REQUEST

Current Zoning: R-3 (single family residential)
Proposed Zoning: MX-3 (mixed use) and UR-2(CD) (urban residential, conditional)

Approximately 240.32 acres located on the west side of Steele Creek Rd, south of Sledge Rd, east of Shopton Rd

PLANNING STAFF REVIEW

-L- (NC 160)

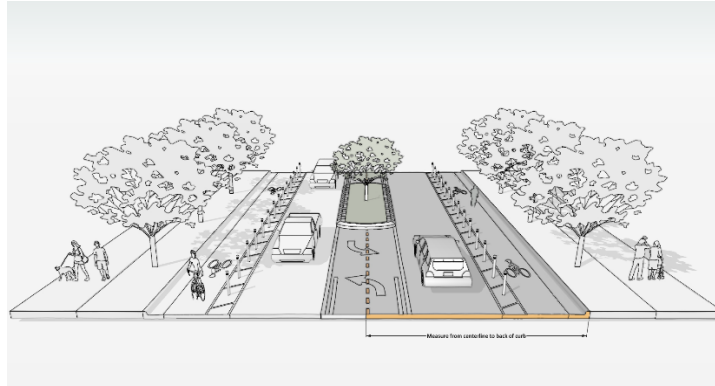
1. **Curblin** The proposed zoning district has a setback measured from back of the existing or proposed future curblin. Label and dimension the curb lines from the centerline.

- a. **Steele Creek Road:** The future location of curb and gutter will be constructed within the Steele Creek Road (NC 160) U-5766 project. The public meeting map and proposed cross section are provided below for reference.

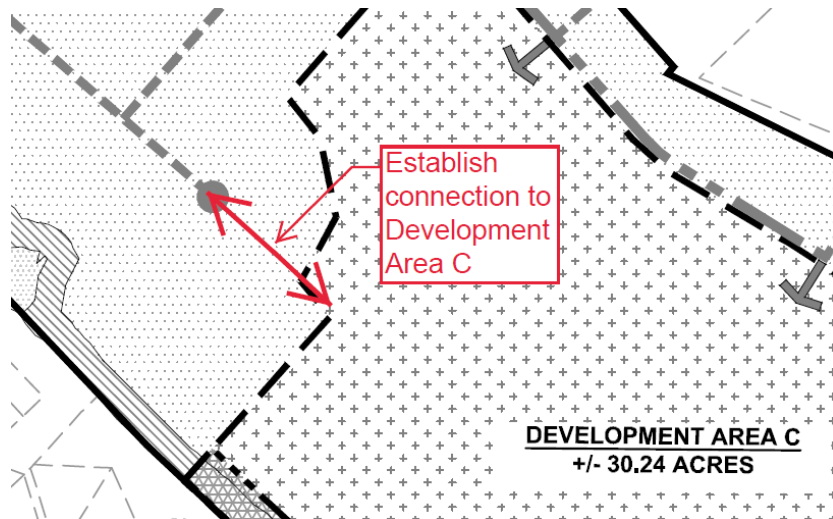
5. The petitioner should revise the site plan and conditional note(s) to incorporate a proposed mini-roundabout on proposed Public Street "A."
6. The petitioner should revise the site plan and conditional note(s) to establish a street connection to "Development Area C."

7. "Development Area C" was removed and/or not labeled, however, access was provided. Please clarify.
